# Comment for planning application 21/01630/OUT

<b>Application Number</b>	<input type="text" value="21/01630/OUT"/>
<b>Location</b>	<input type="text" value="Land at North West Bicester Home Farm, Lower Farm and SGR2 Caversfield"/>
<b>Proposal</b>	<input type="text" value="Outline planning application for residential development (within Use Class C3), open space provision, access, drainage and all associated works and operations including but not limited to demolition, earthworks, and engineering operations, with the details of appearance, landscaping, layout and scale reserved for later determination"/>
<b>Case Officer</b>	<input type="text" value="Caroline Ford"/>
<b>Organisation Name</b>	<input type="text" value="Diane Richardson"/>
<b>Address</b>	<input type="text" value="106 Charlotte Avenue, Bicester, OX27 8AN"/>
<b>Type of Comment</b>	<input type="text" value="Objection"/>
<b>Type</b>	<input type="text" value="neighbour"/>
<b>Comments</b>	<input type="text" value="I wish to object to the proposed development on the following grounds: 1. Increased traffic both during the construction phase and from the new homes once occupied. 2. I believe that the proposal to build building

APPENDIX 2
DEVELOPMENT PARAMETER PLAN 1

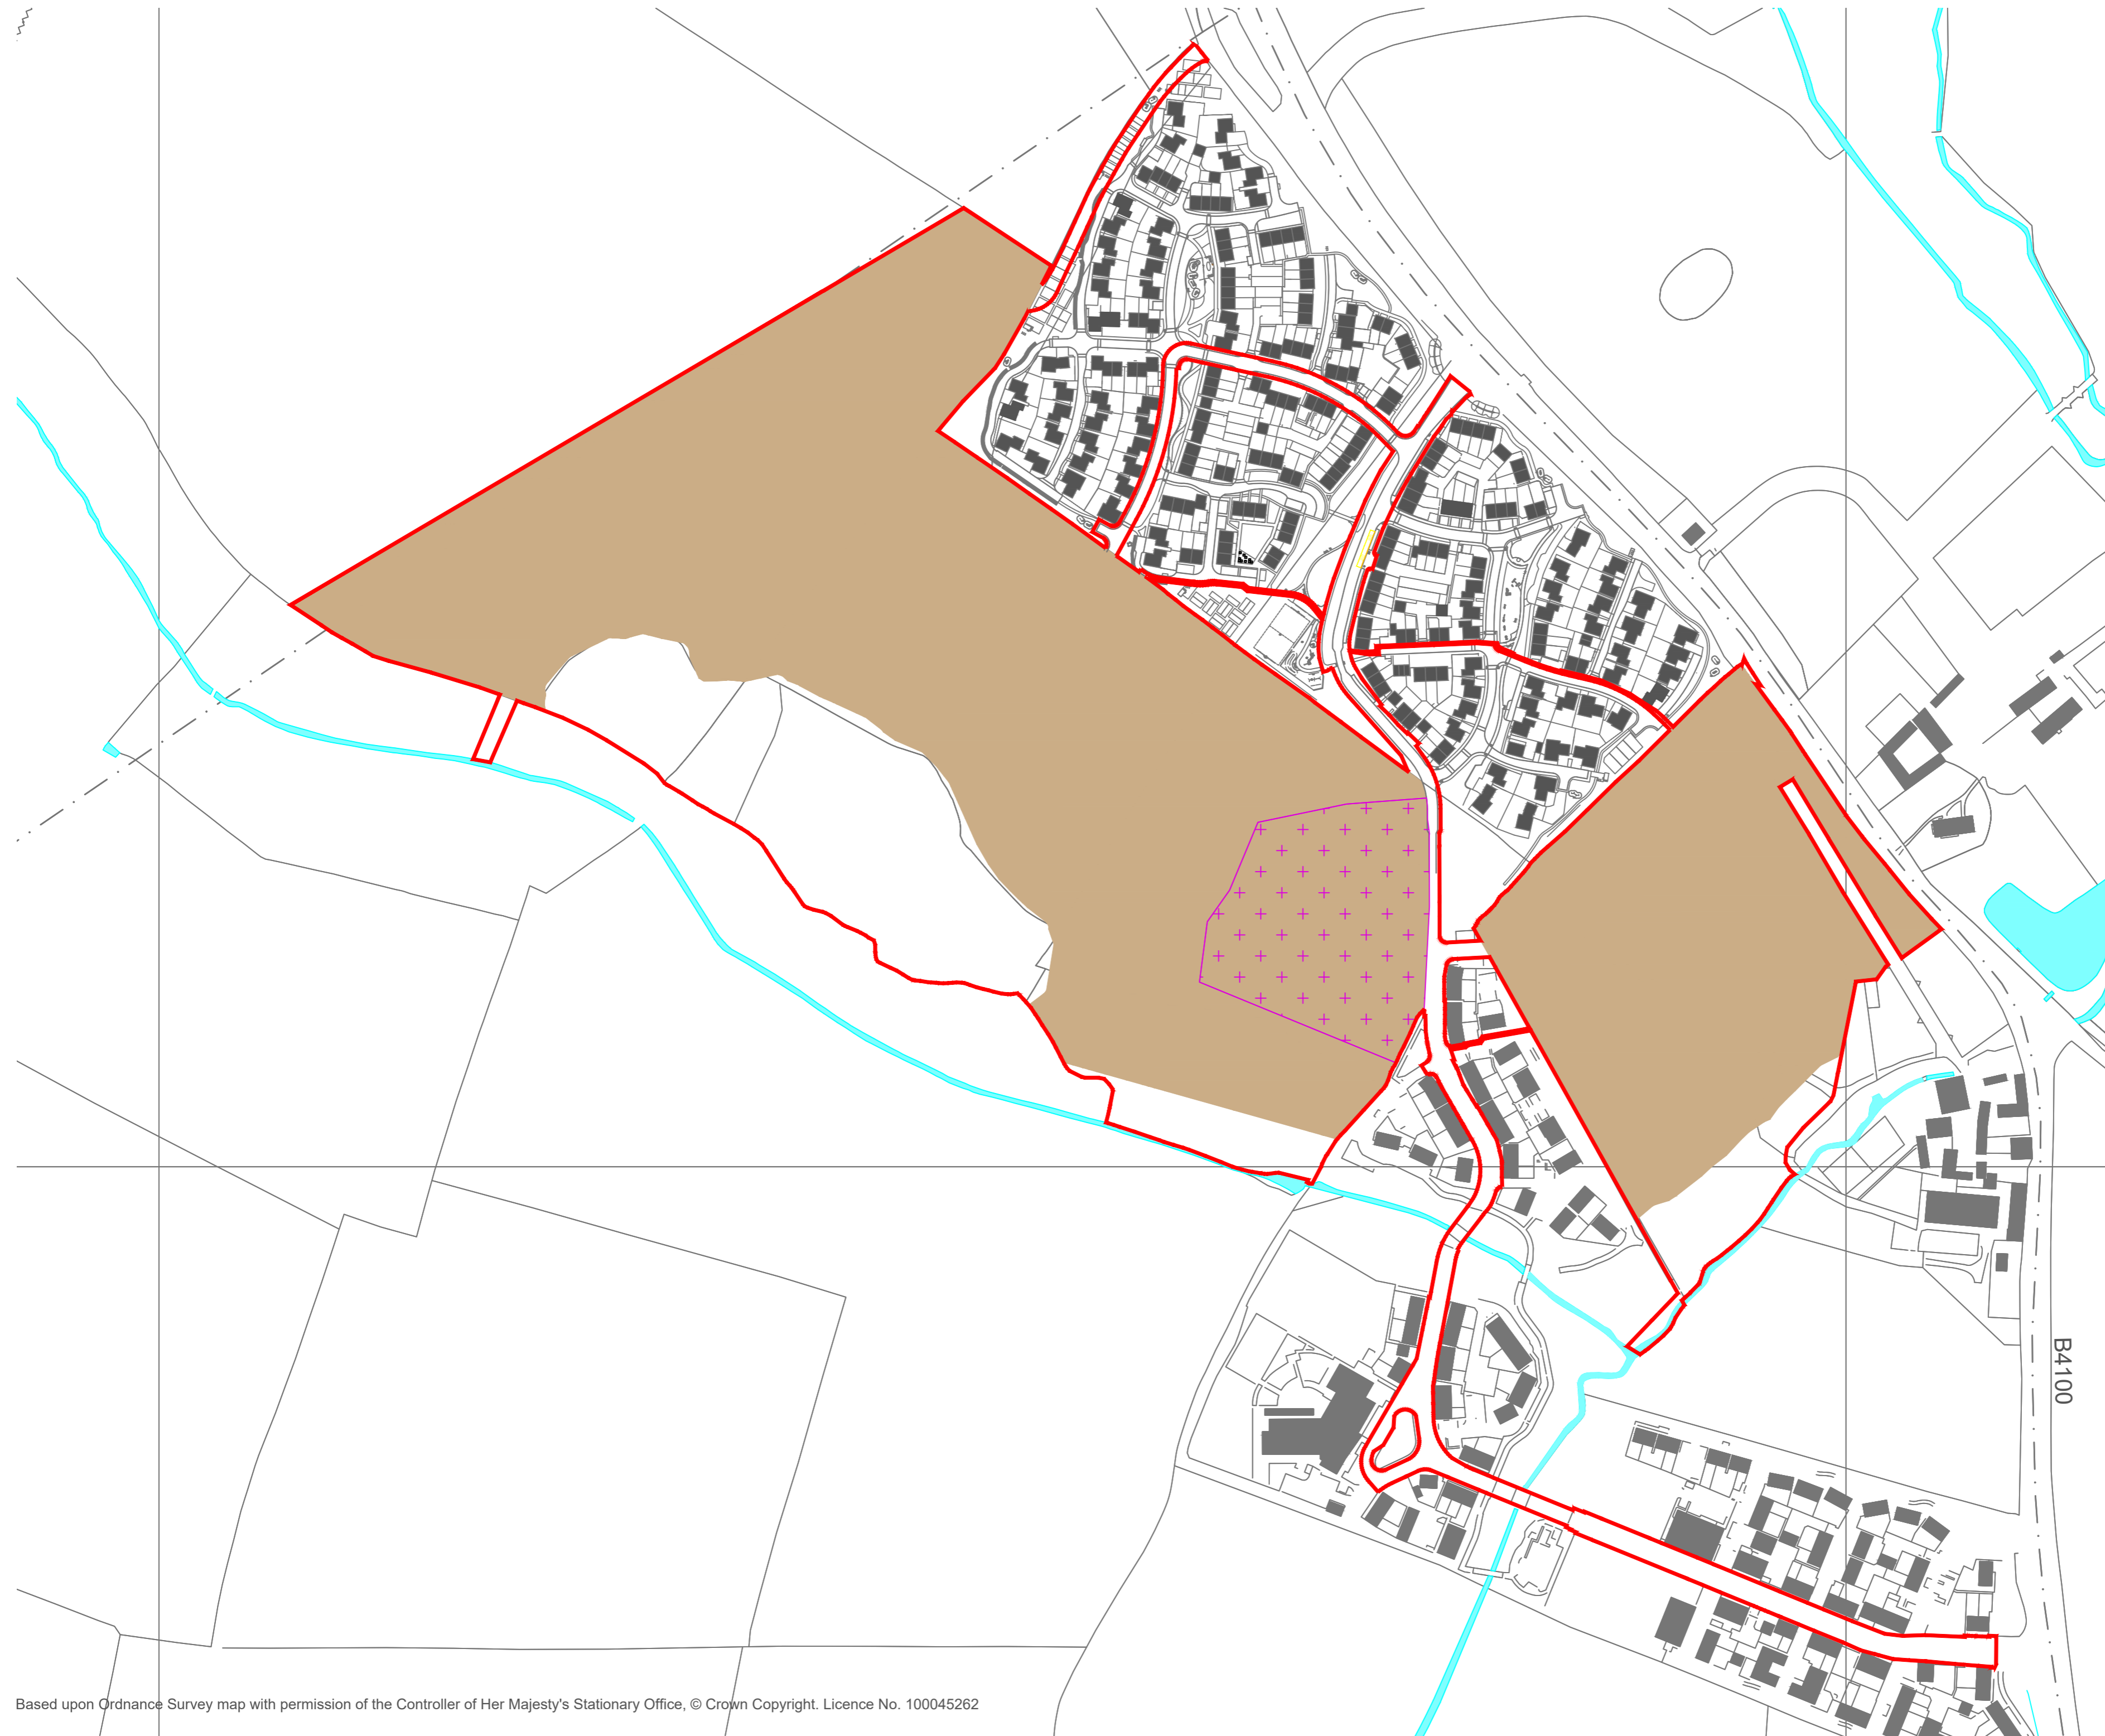
**Secondly** I'm concerned about the number of tall buildings to the west of the bus access link between phases two and three of the Elmsbrook development and along the proposed extension to Charlotte Avenue to create a "frame" the view of St Laurence church. I notice that the proposal includes an application to build buildings 16 metres high (plus or minus 2 metres). This goes against the original Master Plan for the Eco town.

The secondary objection I have to placing such tall buildings of three or four storeys high is that they are placed on one of the higher areas above sea level of the proposed eco development. Therefore these three or four story buildings will have a greater impact on the skyline without the benefit of mature trees to reduce their visual impact on the skyline. I would suggest that such buildings if built are built where the site is at its lowest near Lord's Farm in a later development phase.

If they must be built in the location indicated then they will need screening from the houses opposite in Charlotte Avenue and to reduce the impact of high buildings in the area. Another alternative would be build them along the Southern edge of the development where the existing mature trees would reduce their visual impact on the skyline and landscape. This would also more

**APPENDIX 4
DEVELOPMENT PARAMETER PLAN 3**

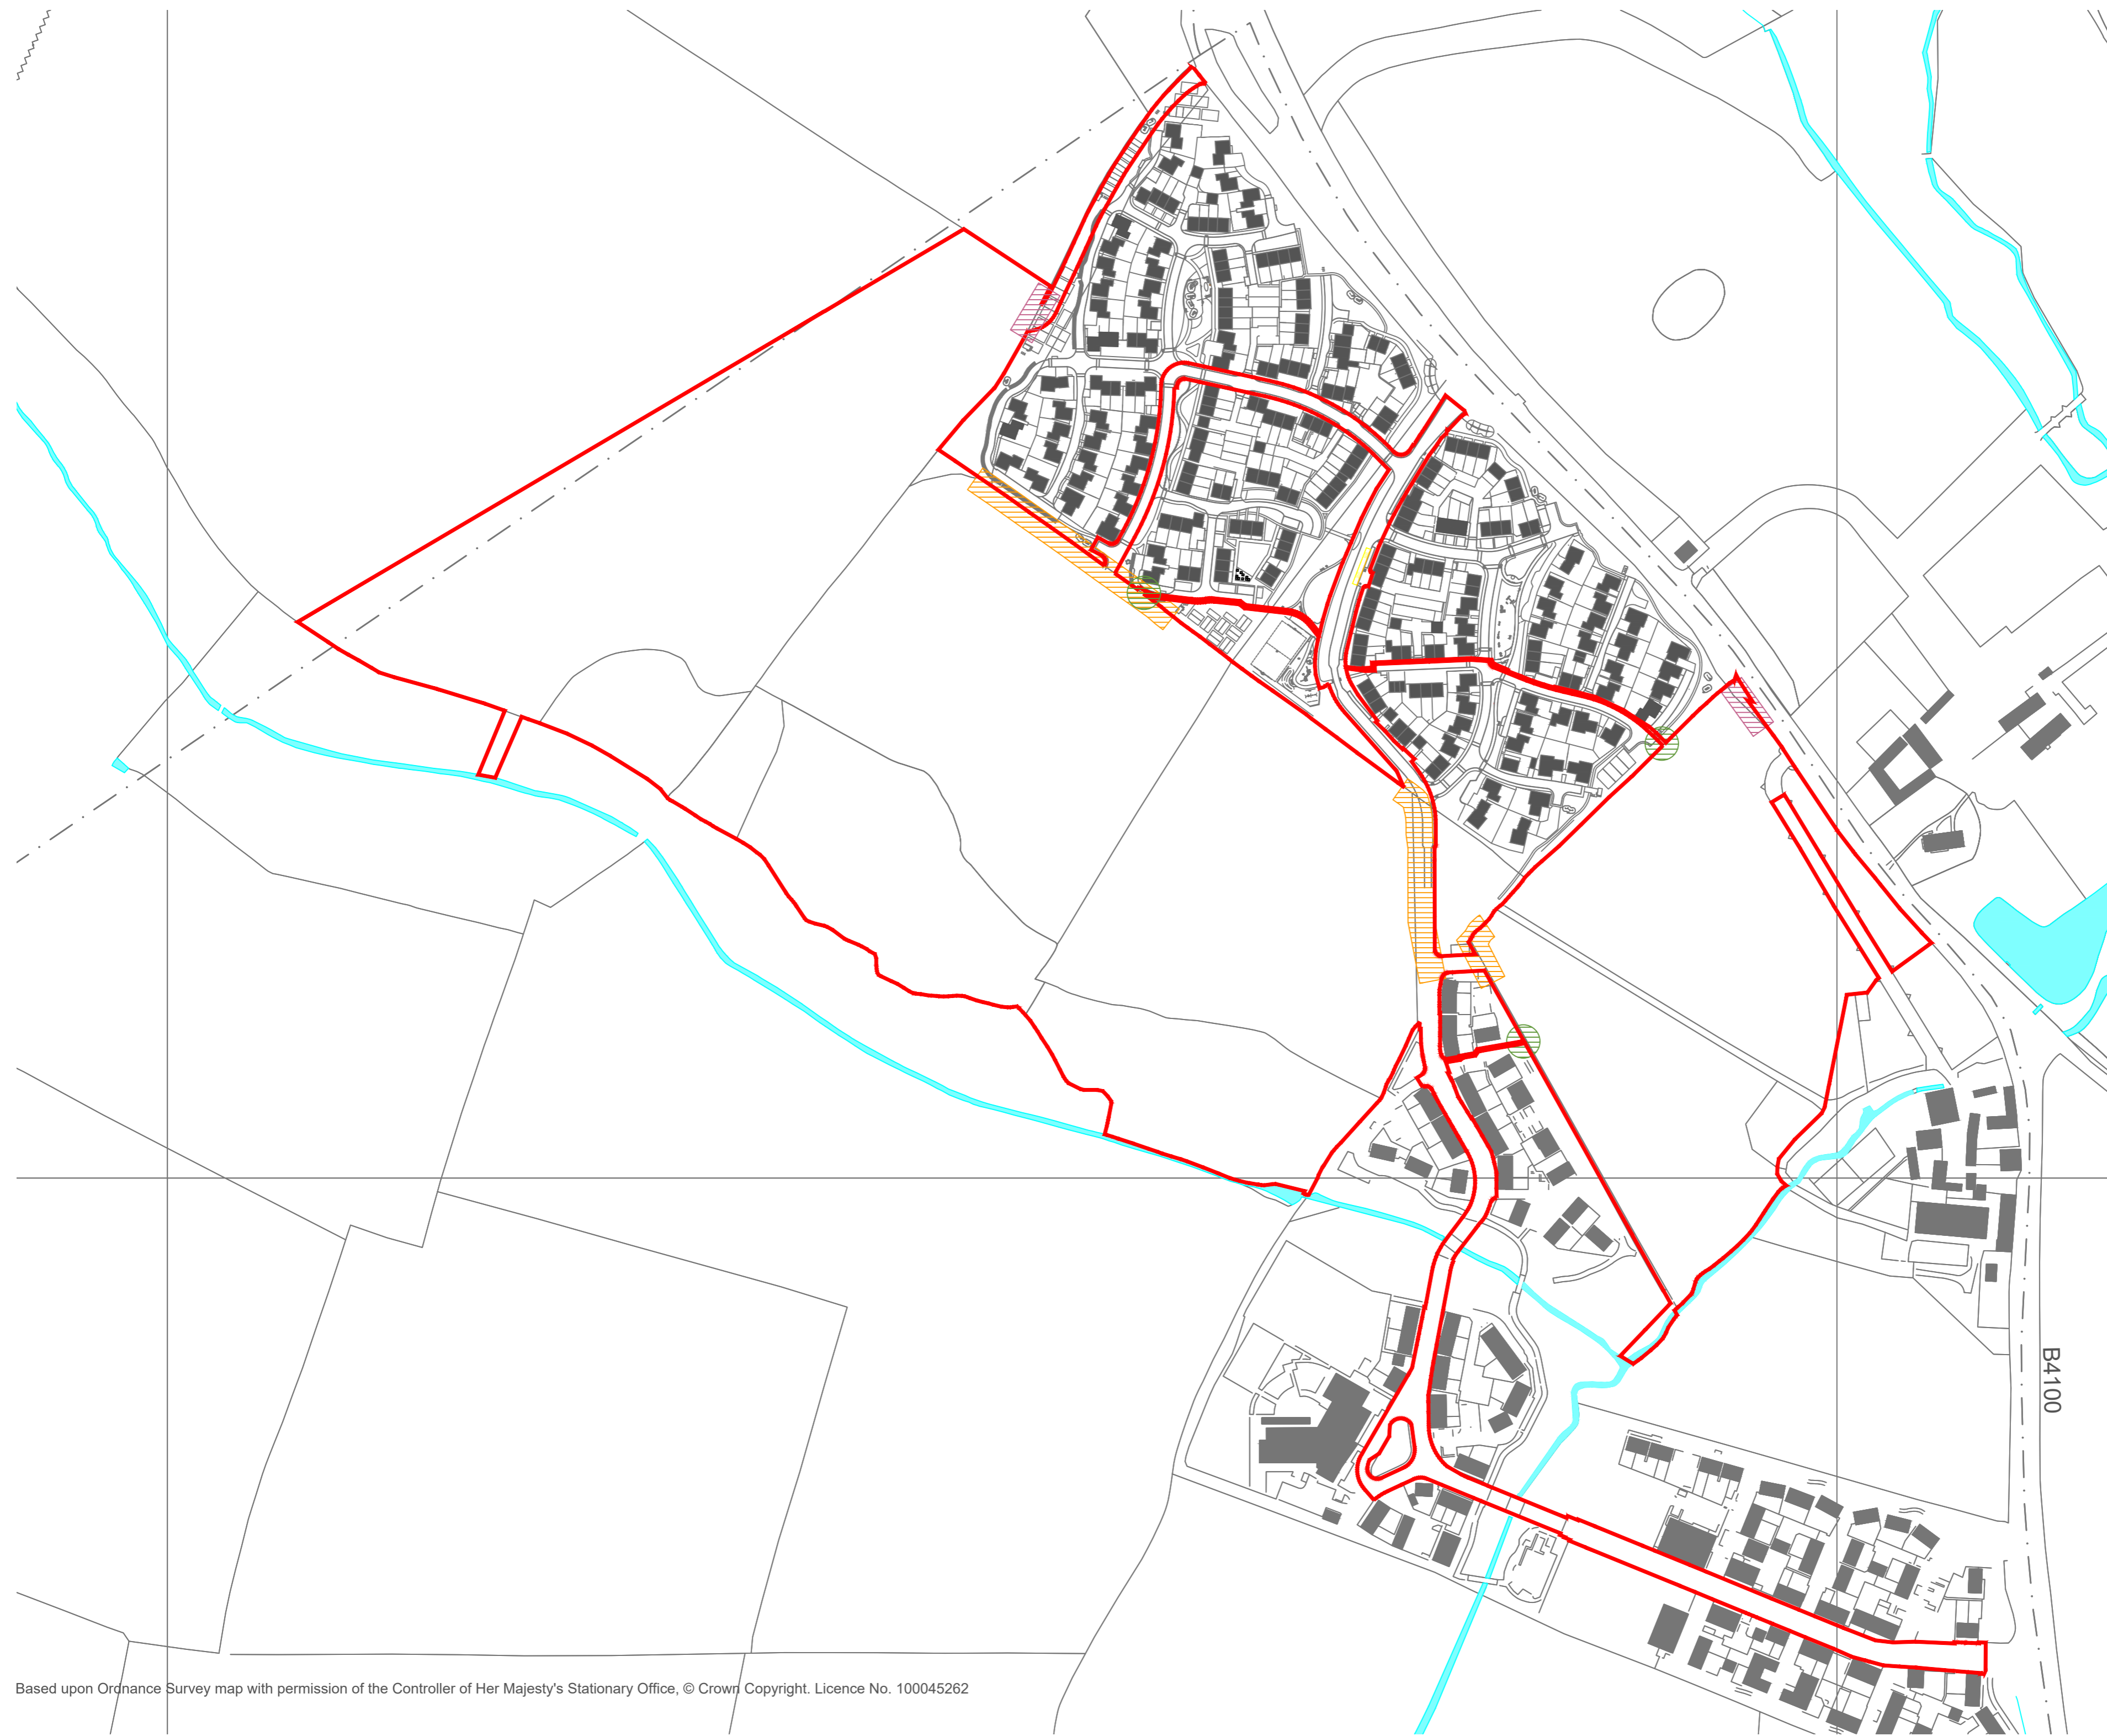
I am concerned about the access that construction traffic would have to the sites. During the constructions of phases three and four of the Elmsbrook development heavy construction traffic regularly used Charlotte Avenue to gain access despite there being much easier access to phases three and four via the designated road, Braeburn Avenue. This is a safety concern as the roads are not designed to be used on a regular basis by heavy trucks as well as causing additional travel delays. Past experience suggests that trucks will ignore any restriction (as they currently do. ignoring the no construction Access signs at the junction of Charlotte Avenue and the B4100 – Banbury Road) and gain access via Charlotte Avenue, as it is the most obvious point of site access.

The proposal to build 530 houses will also need careful traffic management. the existing plans say that these new homes will be accessed via the existing roads of Charlotte Ave and Braeburn Avenue.

Neither of these roads is built to take this amount of traffic, they have numerous traffic calming measures in place, including width restrictions, deliberate narrowing of the road and “blind bends”. I can see many traffic delays caused especially during the morning and evening peak hours as people leave for work or to undertake “school runs” and return home at the end of the day. The existing level of traffic causes minor congestion as parents wait for their children to leave Gagle Brook Primary School each afternoon and park on Charlotte Avenue which can restrict the free movement of traffic.
